Application Number	AOD/23/00105
Planning Application	Conditions 2, 5,6,7,9,10, 11, 12, 13, 14, 15, 19,20, 21, 22, 23, 24, 26, 27, 28, 29, 30, 31 and 32 of 20/01546/FUL
Address	North Selby Mine, New Road, Deighton, YO19 6EZ
Planning Officer	William Elliott
Date	9 th April 2023

This department has reviewed the information submitted in support of the discharge of conditions 19 (CEMP), 20-23 (Land Contamination) and 24 & 26 (Noise).

Acoustic Barrier Fencing

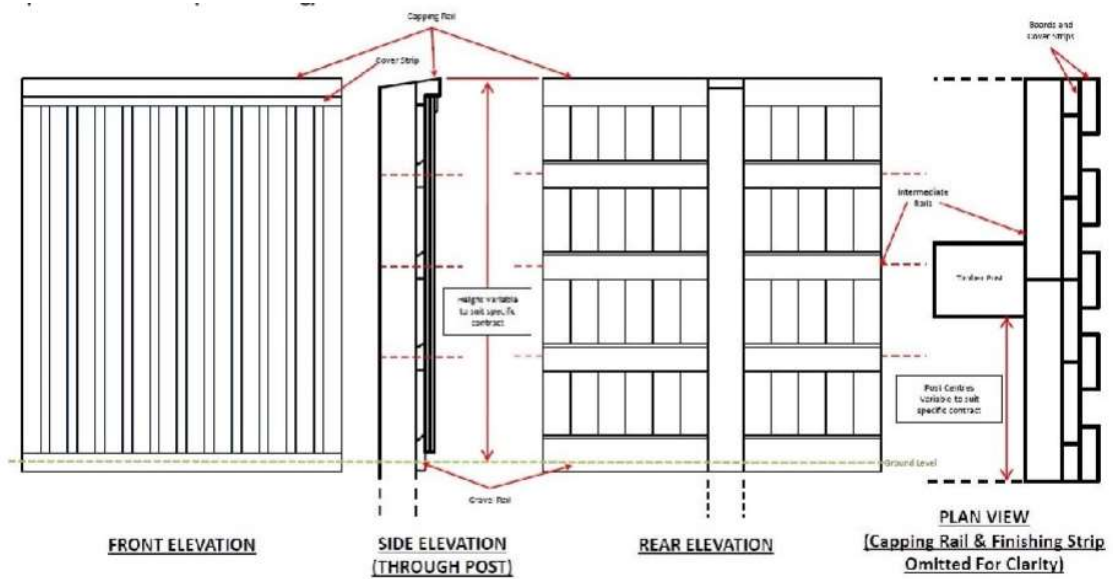
The applicant has submitted details of the noise barrier including the density and the sound reduction qualities of the barrier, However a detailed plan of the specific location of the barrier has not been included. This should be included before consideration is given to the discharge of condition 26.
